### **POST SUBMISSION ADVICE FROM OFFICERS**

**From:** [Emma Lancaster](#)  
**To:** [Caroline Ford](#)  
**Cc:** [Johnathan Welton](#); [Kelvin Pearce \(kelvinpearce@albionland.co.uk\)](mailto:kelvinpearce@albionland.co.uk); [Chris Smith \(chris.smith@cornisharchitects.com\)](#)  
**Subject:** RE: 21/03177/F - Axis J9 Phase 3, Howes Lane, Bicester  
**Date:** 02 March 2022 16:31:00

**From:** Caroline Ford <Caroline.Ford@Cherwell-DC.gov.uk>  
**Sent:** 18 February 2022 17:35  
**To:** Emma Lancaster <emma.lancaster@quod.com>  
**Cc:** Johnathan Welton <johnathan.welton@quod.com>  
**Subject:** 21/03177/F - Axis J9 Phase 3, Howes Lane, Bicester

Fig. 16 Unit 4 Elevations

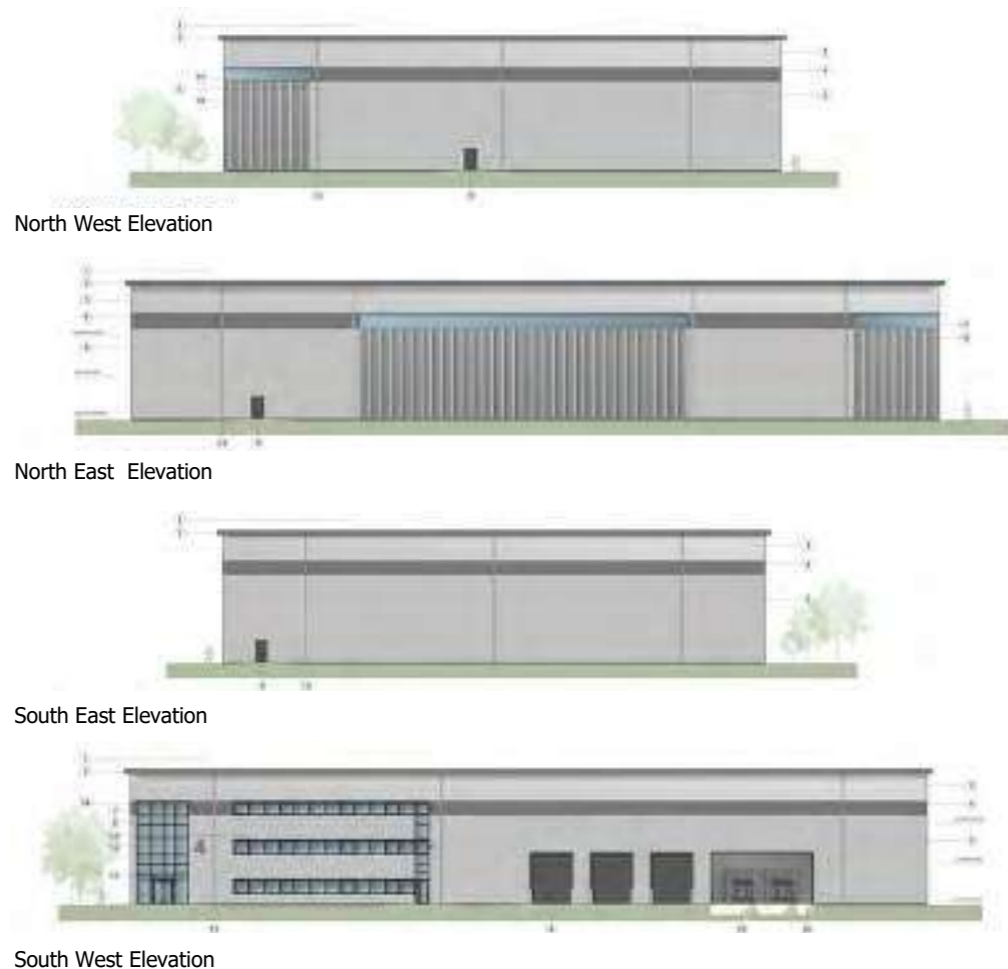
- I wonder if the north east elevations of unit 4 could be activated further (perhaps in a similar way to unit 5) bearing in mind a road located to the north of this unit and its prominence when viewed from the north in the future.
